Your Ref: OWQC25588
Our Ref: BR/5/20/PL
Please ask for:
Amber Willard

Reduce size of existing flat roof rear extension, new lantern light, changes to fenestration & extension of boundary wall on north east elevation.

114 Victoria Drive Bognor Regis

Thank you for your internet comments made on 30th January 2020 which has been recorded as **'an objection'** with the comments as follows:

Existing Ground Floor Plan

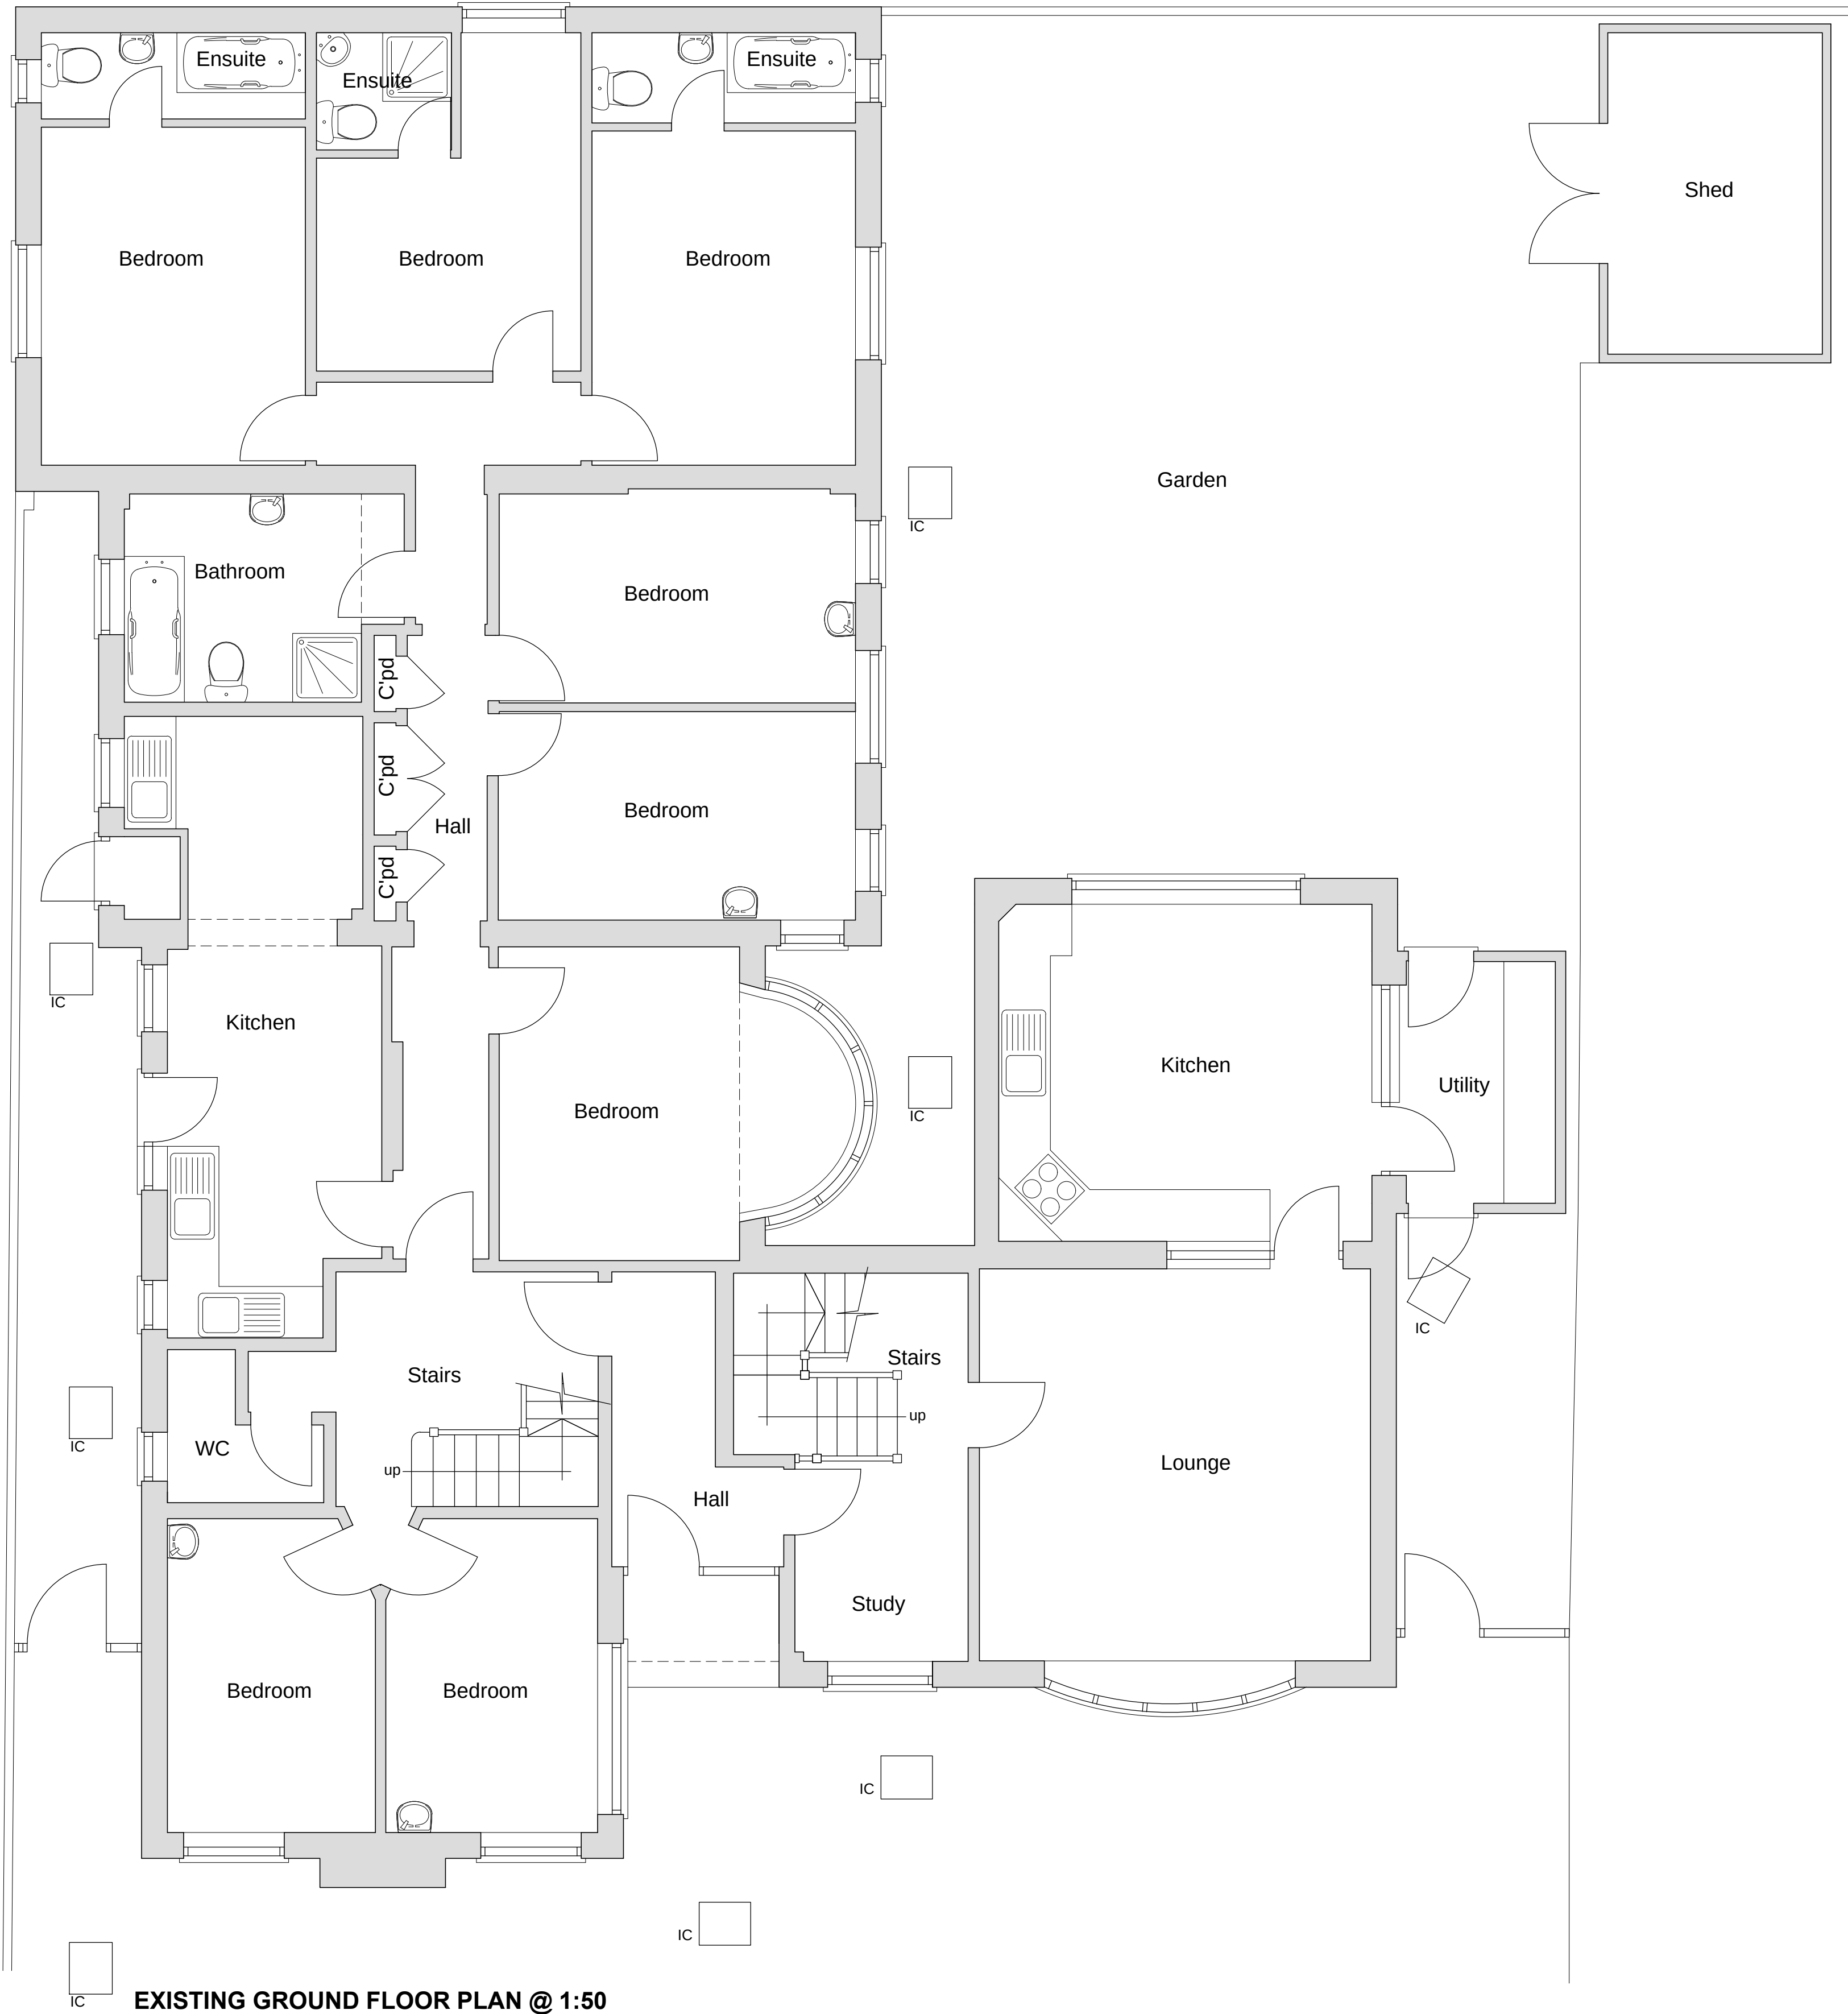
OBJECTION According to the plans the property is currently a 17 No. bedroom House of Multiple Occupation. It is unclear why the 3 No. bedrooms currently located in the rear extension would be relocated on the Ground Floor, in place of 1 No. bathroom and 1 No. kitchen, to allow for a kitchen in the rear extension. The proposed reconfiguration on both the Ground and First Floors would result in the loss of 5 No. ensembles and 3 No. WCs in total. There are concerns that these seemingly unnecessary changes are the precursor to a future application to increase the number of bedrooms even further. Whilst the property has a relatively large amount of off-street parking, it is not considered to be sufficient for a 17 No. bedroom (or greater) HMO in an area that is known to have problems with on-street parking. Members are of the opinion that this application is over-development.
